From: Graeme Thorpe
Sent: 04 January 2012 08:57
To: Jane Tucker
Subject: FW: COMMENTS ON PLANNING APPLICATION 3/2011/0971

Planning Application 3/2011/0971 Cobden Mill Sabden

Type J
Close Boarded Fence
Elevation

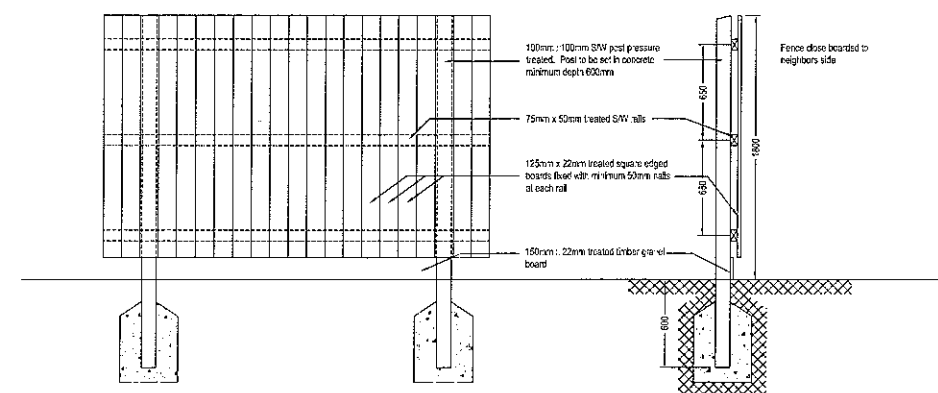
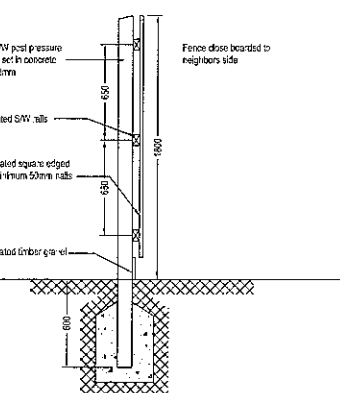
3. **The close boarded boundary fencing** is causing some concern as wooden fencing is high maintenance & soon becomes in disrepair. The other concern is that gateway access' could easily be made onto Pendle St East & along side of the Bowling Green. The parish council would prefer a more permanent structure e.g stone wall or lowering of existing wall

Landscape Proposals Cobden Mill, Sabden

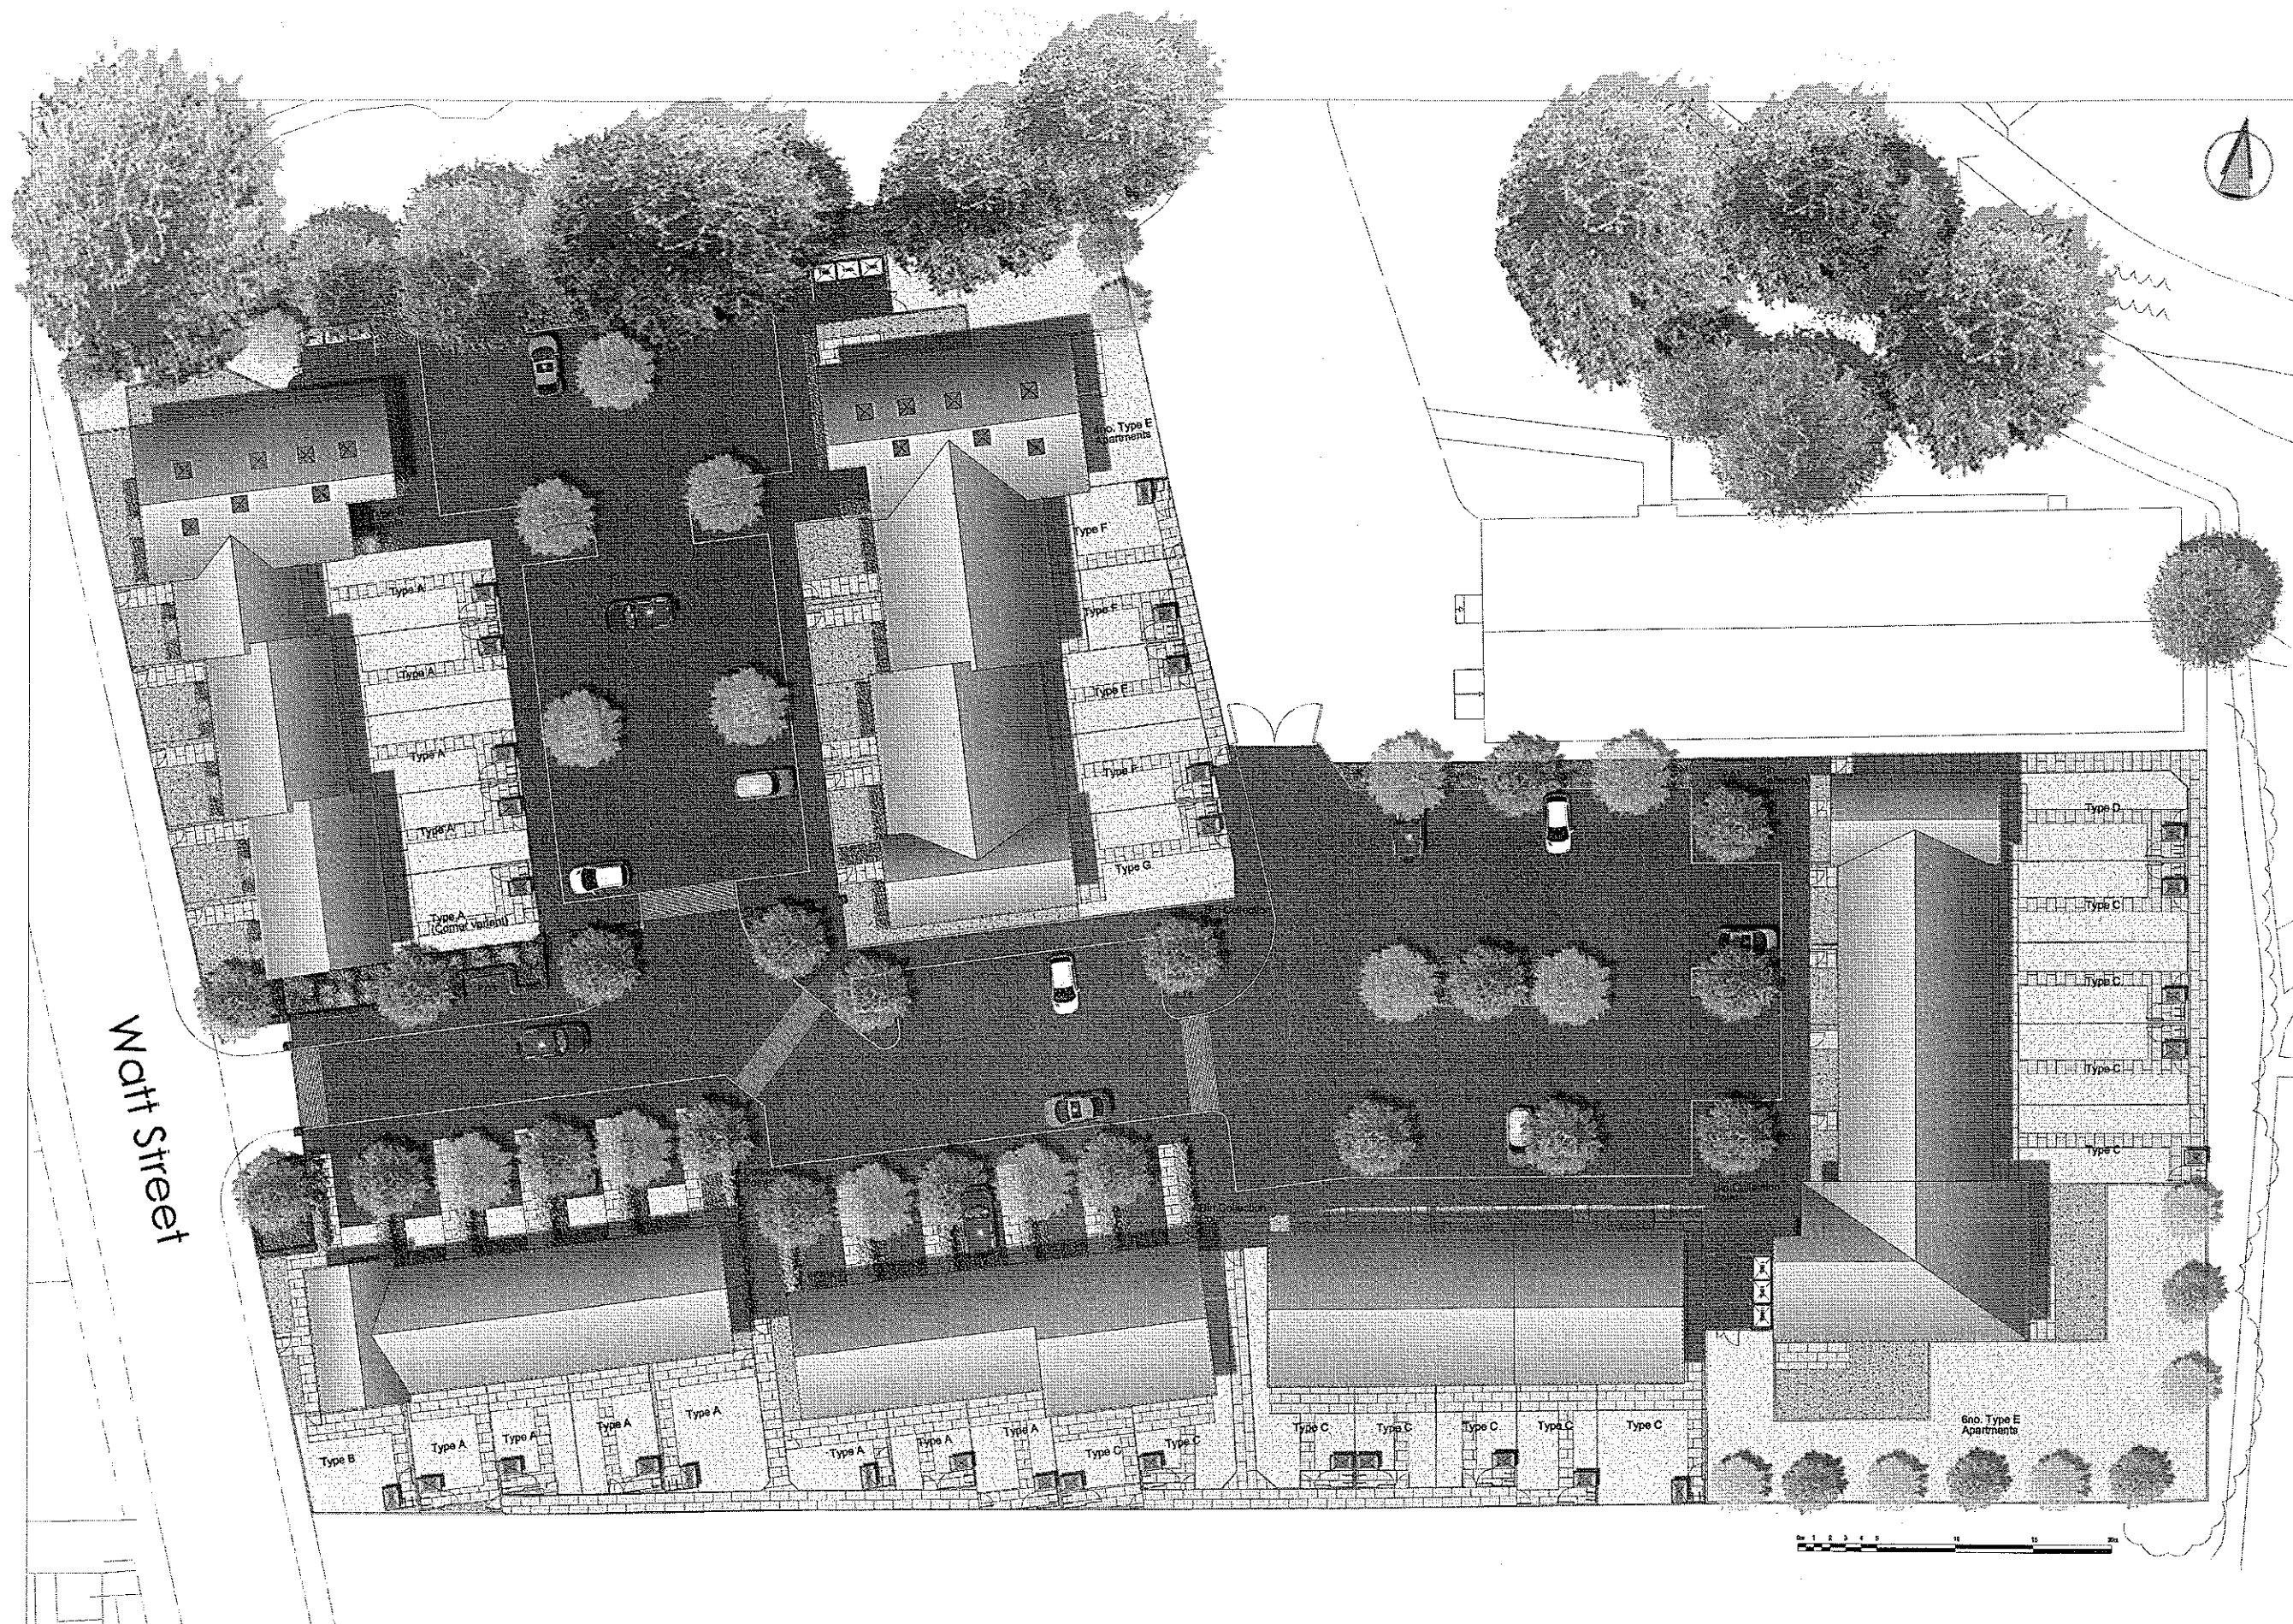
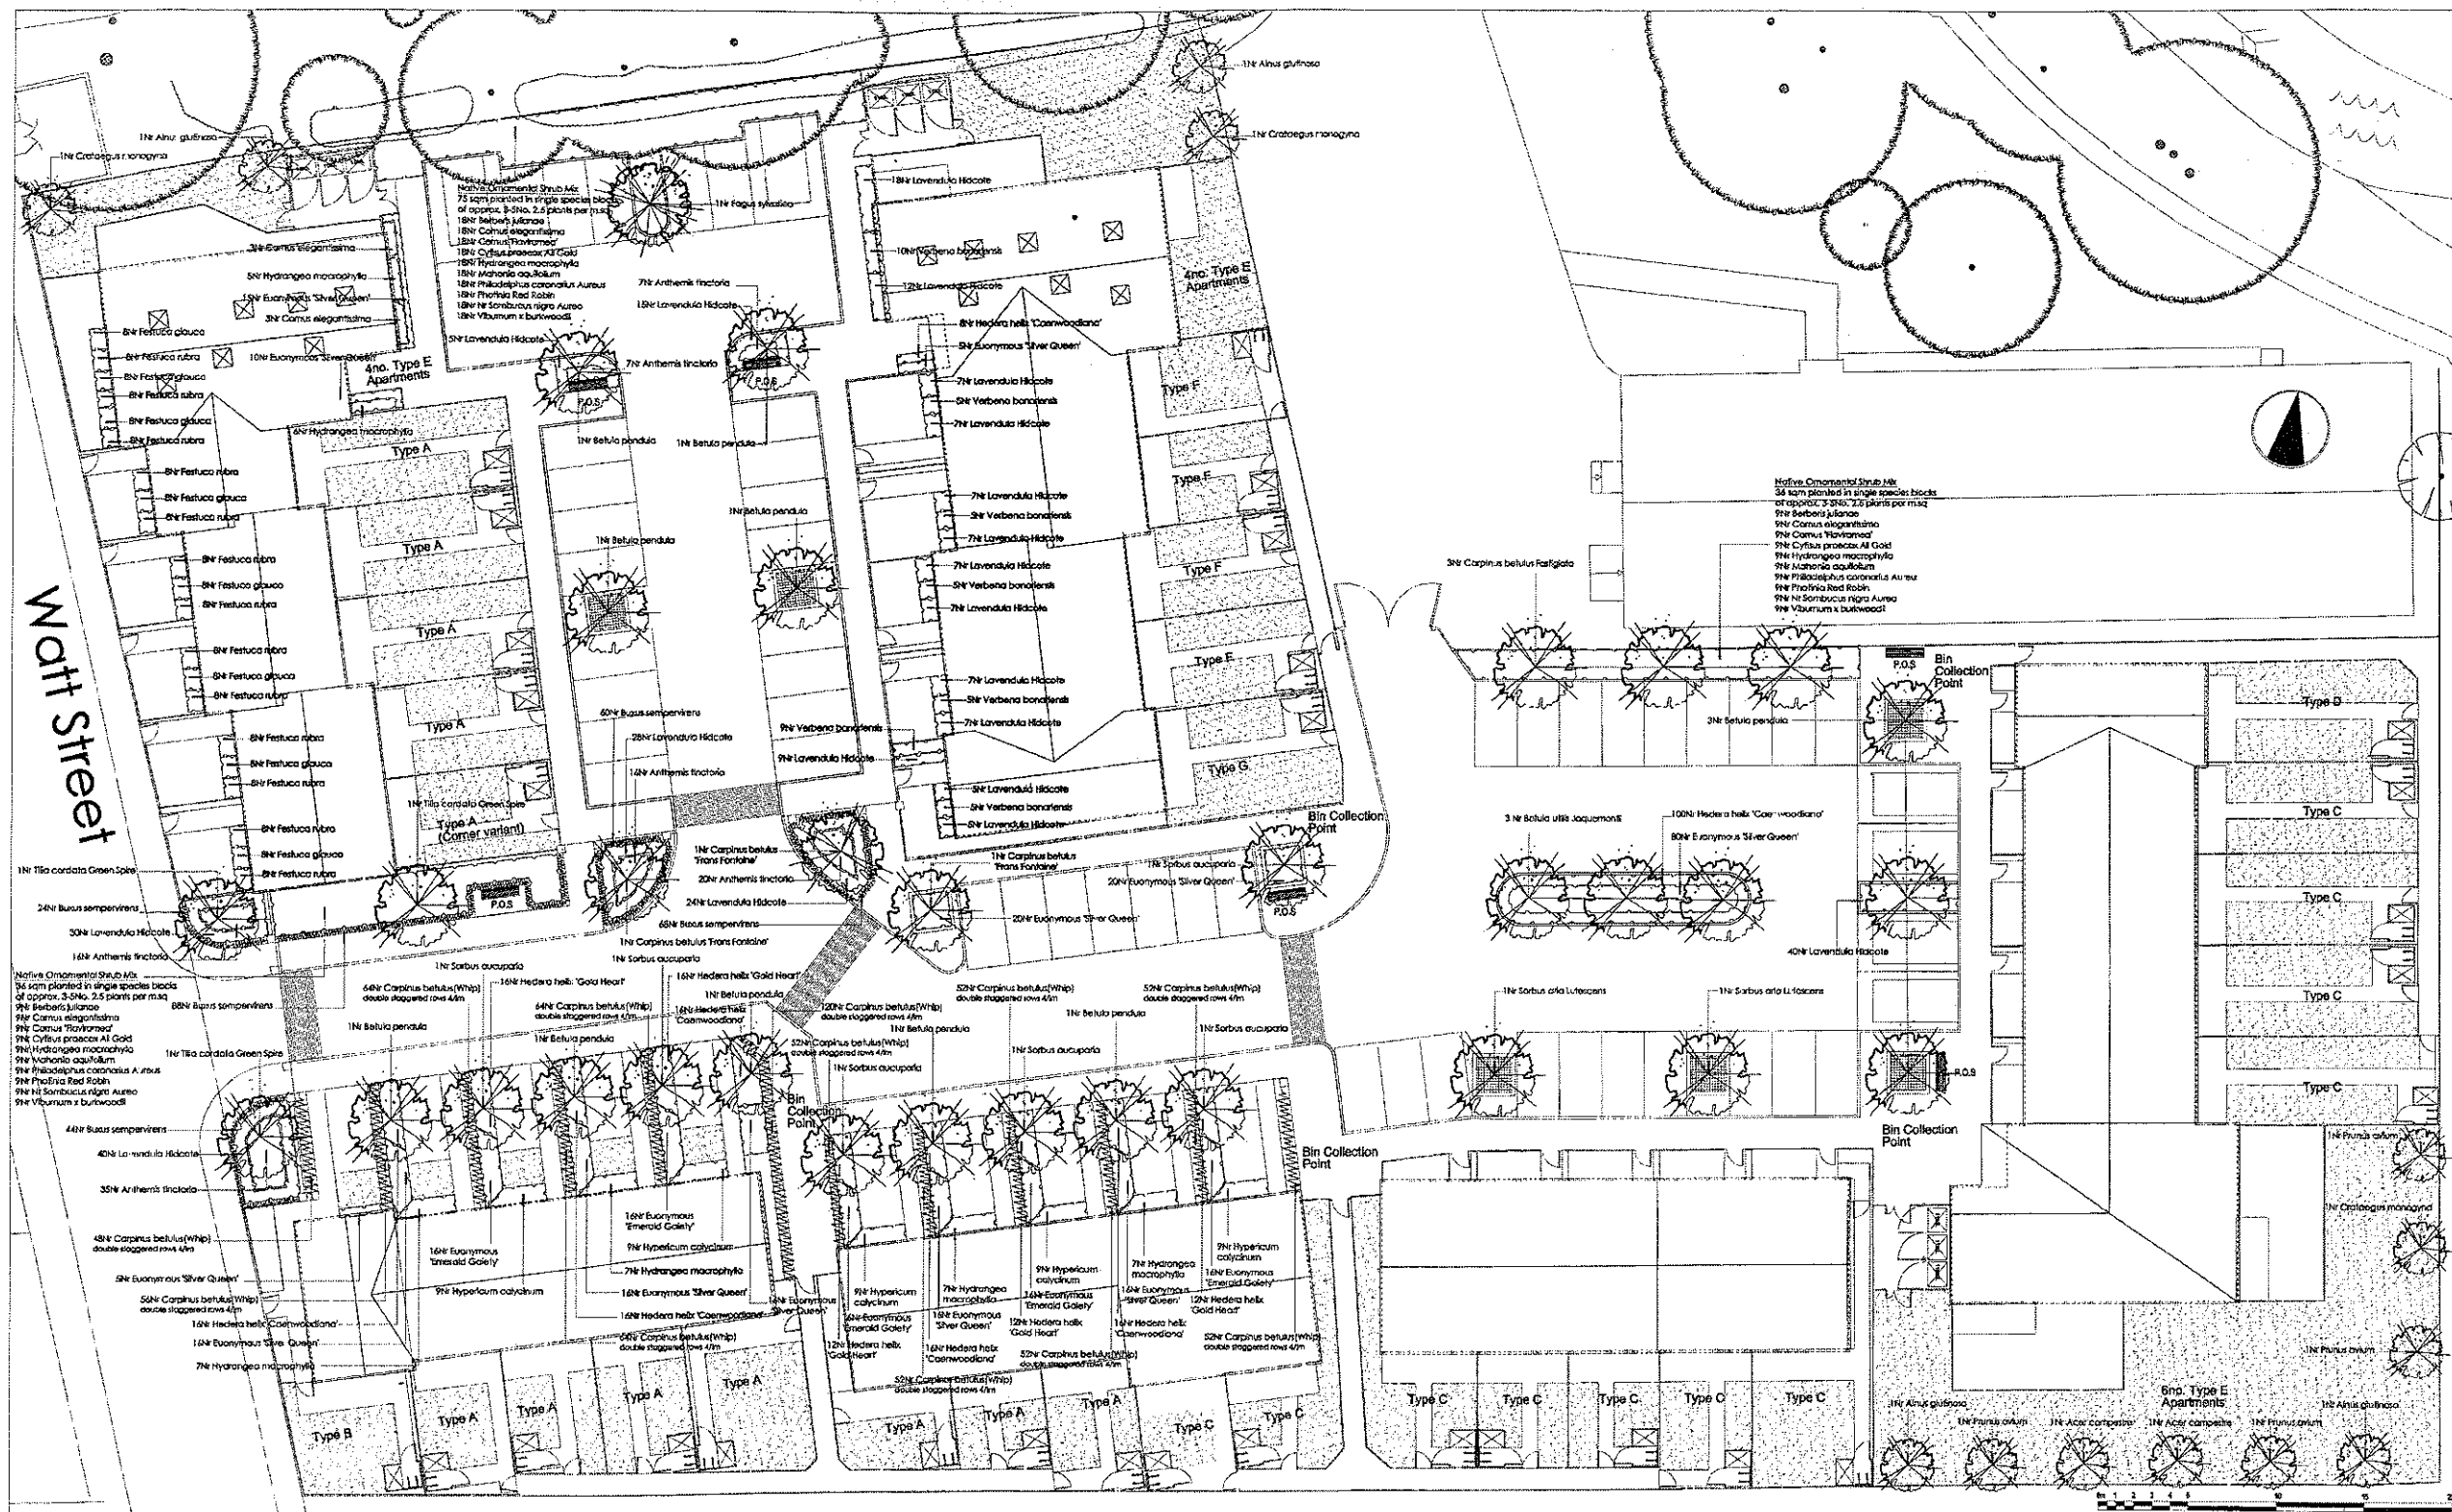
4. The plans do not show a pedestrian access leading from the site onto Whalley Road in the vicinity of Cobden Bridge, the parish council feel it would be beneficial for pedestrians to have access to Whalley Road at this point.
